4 December 2024

Application: 600-660 Elizabeth Street, Redfern (Lot 1 in DP 1249145)
Application No: SSD-51274973

Please note that the comments made in this letter, are largely in relation to the findings within the Social Impact Assessment_Final document that was prepared for Bridge Housing Limited on 28 June 2024.

Status:
STATE SIGNIFICANT DEVELOPMENT APPLICATION
Drawing Title:
BUILDING ELEVATIONS

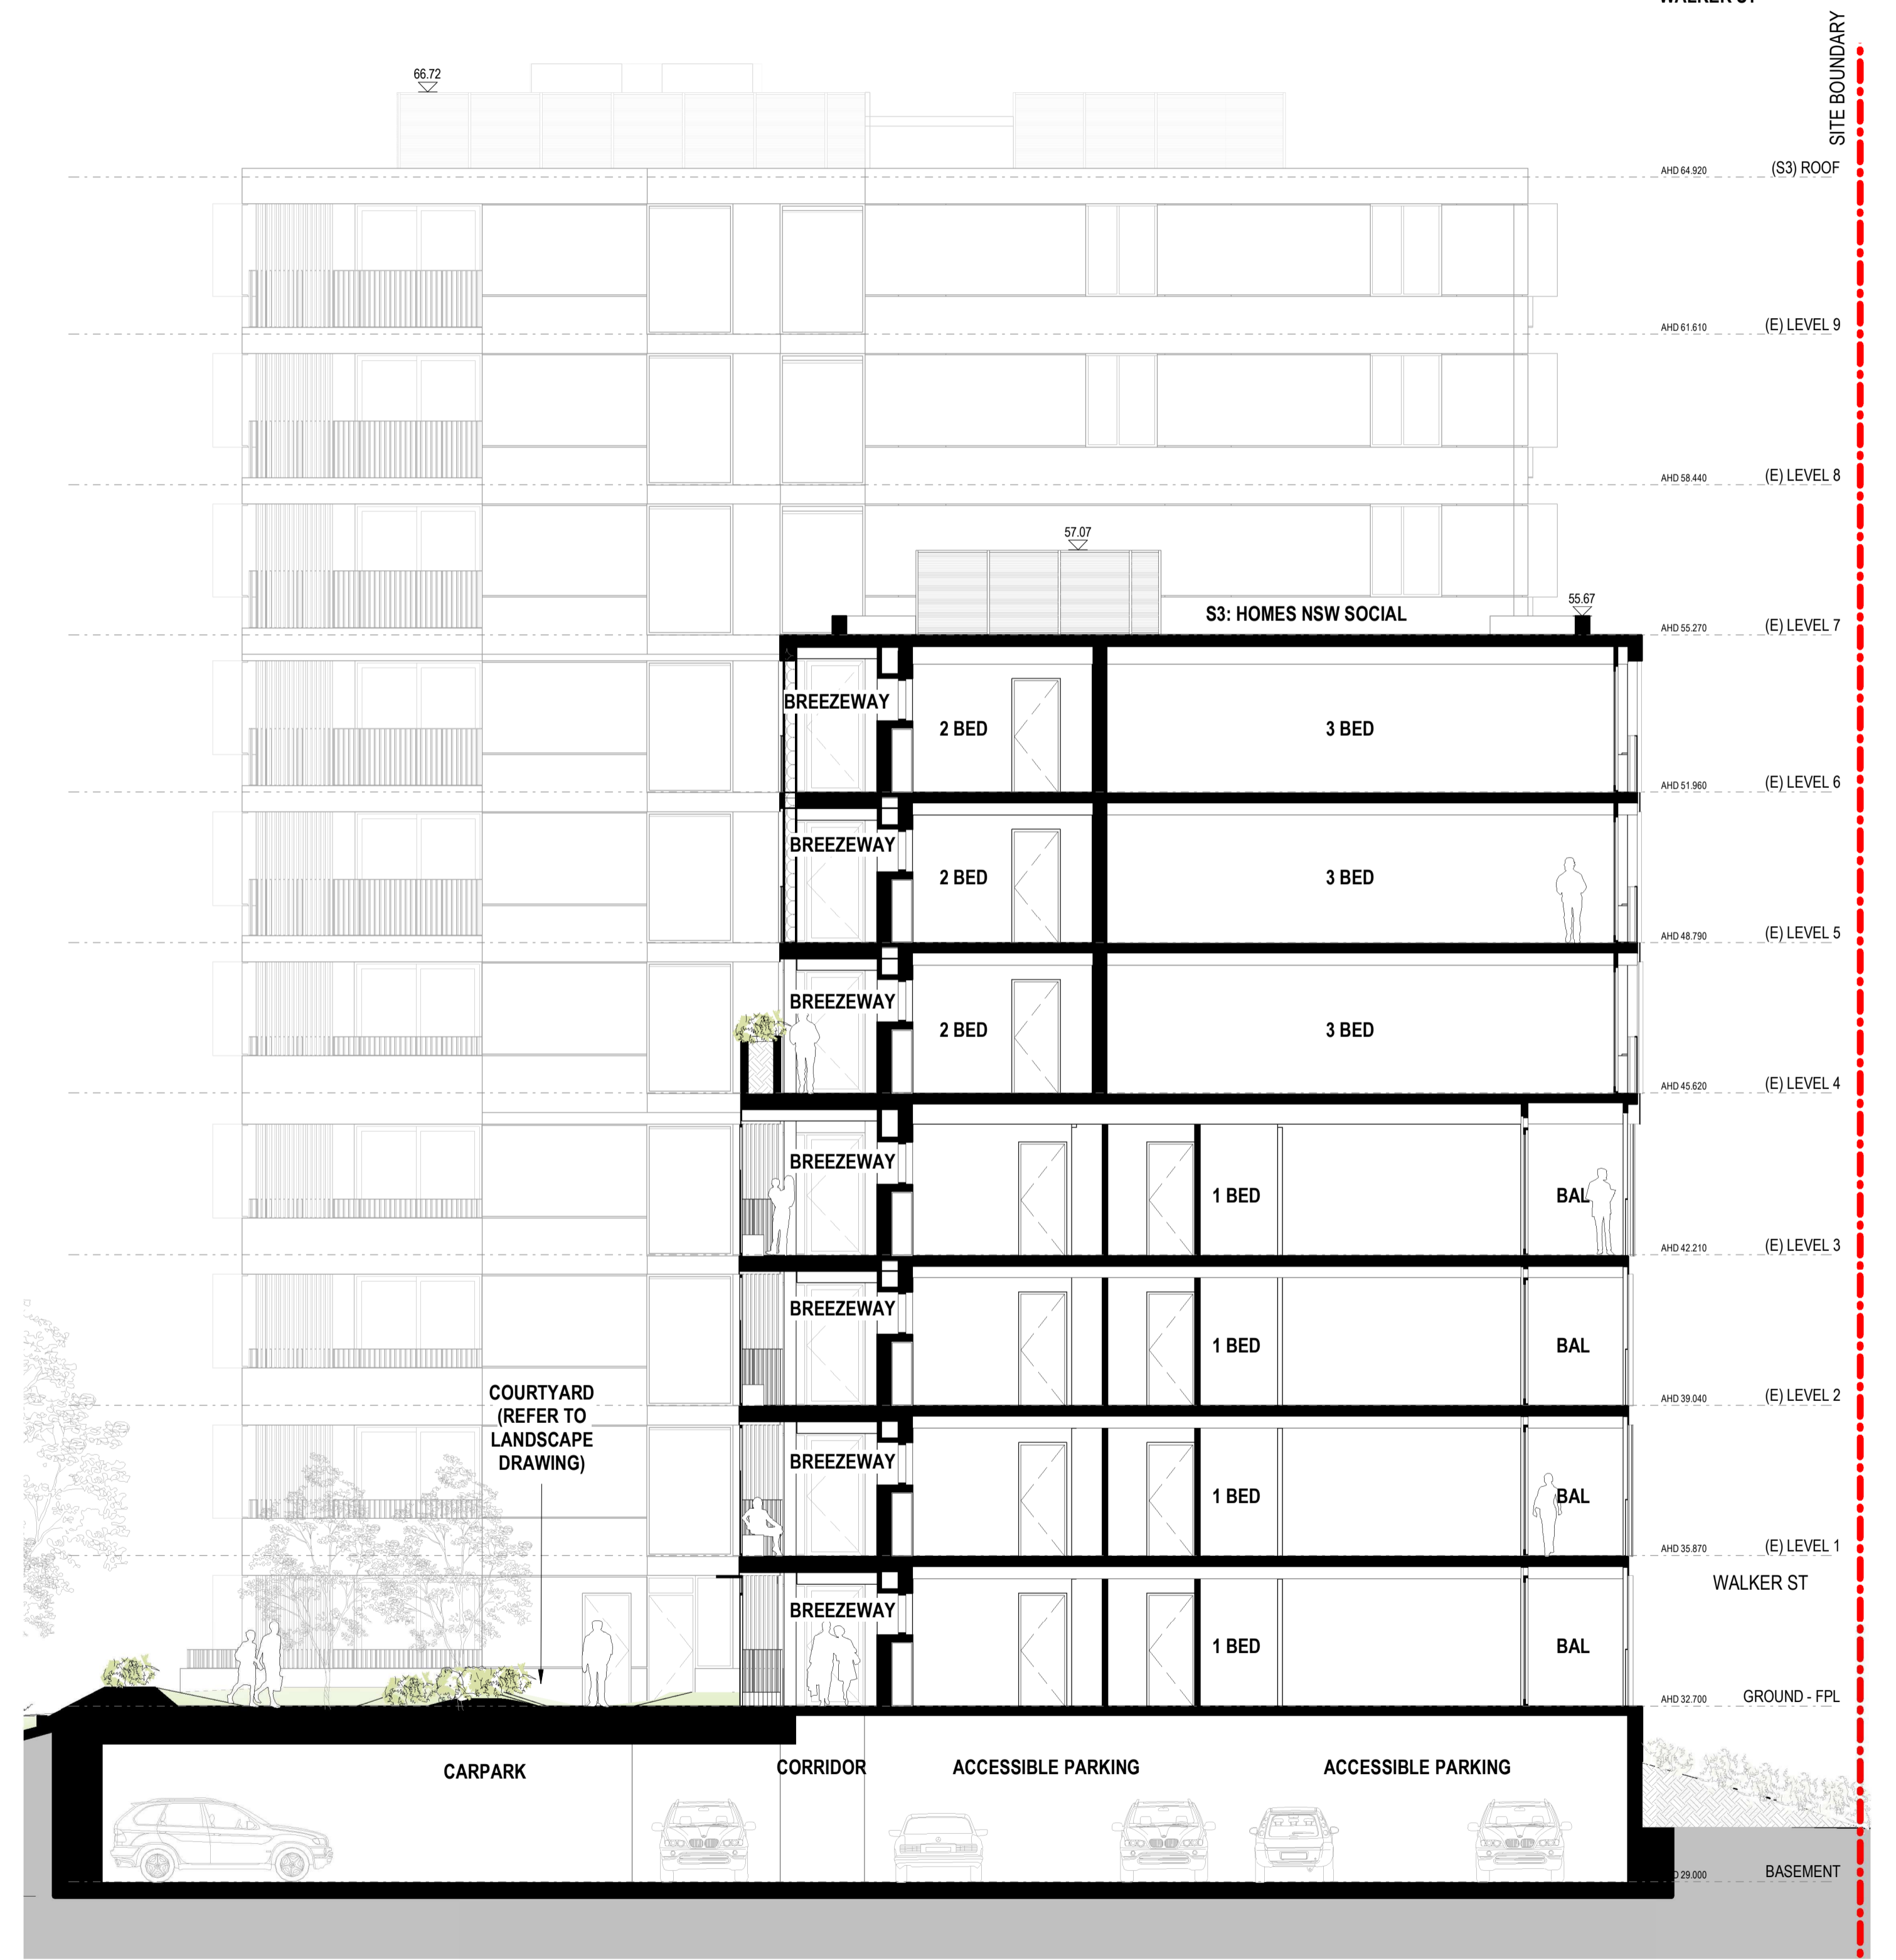
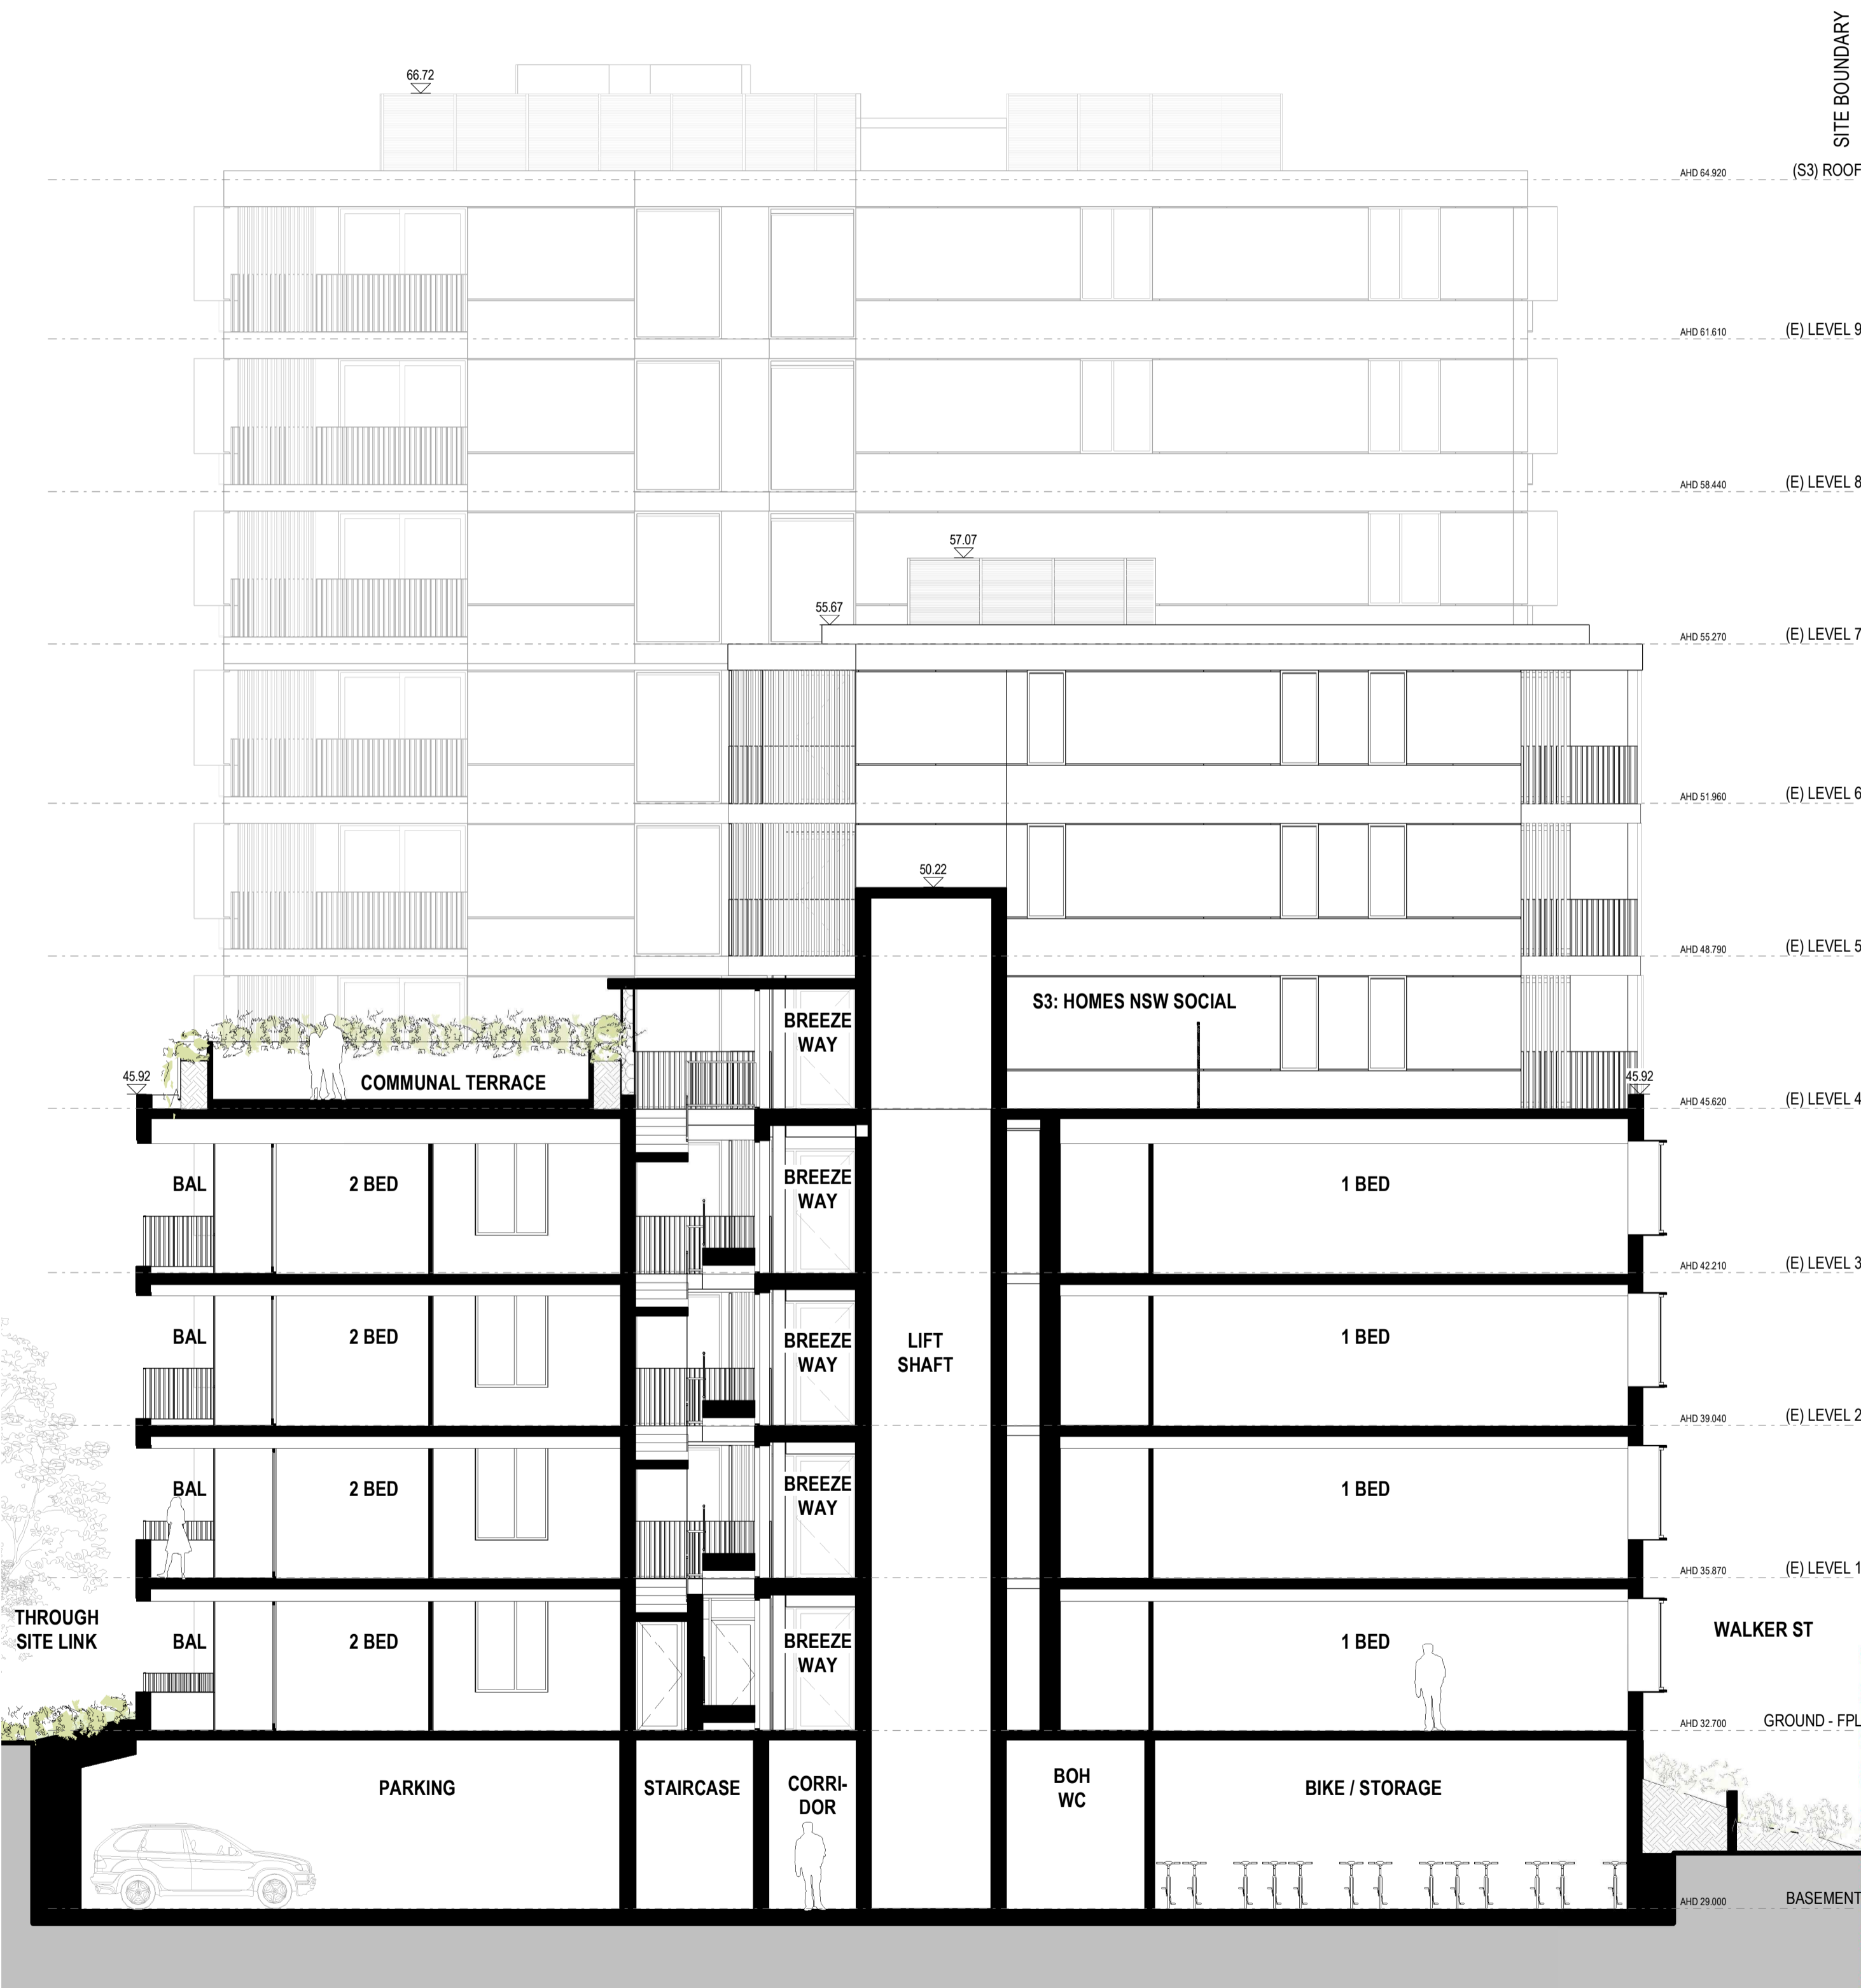
The future looks much different from Phillip Street looking north, with the S3 building set back from the existing street kerb gutter about 8 metres, and then rising 16 metres (5 storeys) high to top of balustrade and keep rising, as you look at Redfern Place to the north.

Please note that I refer to page 15, point (I) under Design Guide. It refers to a “built form that responds to lower scale of building to the south”. We do not agree you have met that goal, with the design of Redfern Place, with your set back from the street and the height of S3.

PHILLIP STREET ELEVATION

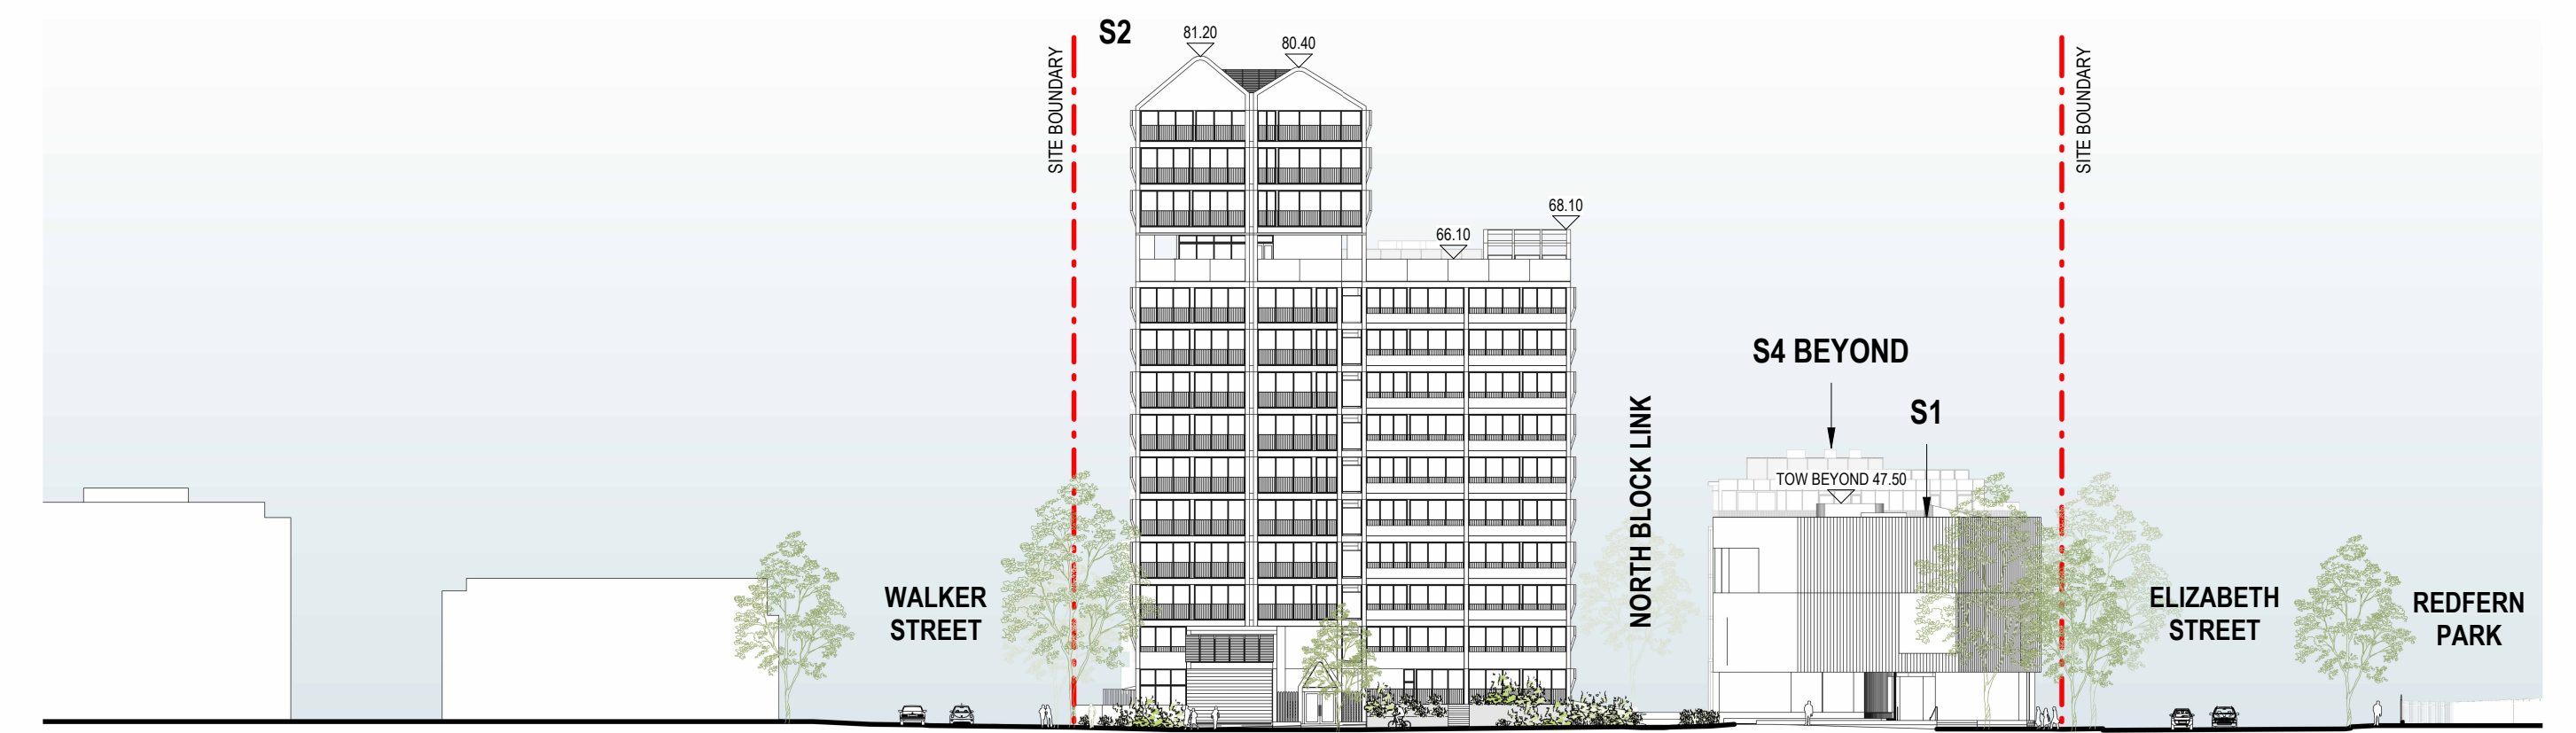
Phillip Street, as of now, from Beaumont Street to Walker Street, looking north, has the back of the PCYC about 6m high to top of roof, and then a sports court with playground with trees. The PCYC is set back from Phillip Street by a council footpath which is approximately 7 metres, so from street kerb 11.5metres, with a mature gum tree on footpath, and more trees to hide sports court, plus provide shade to playground.
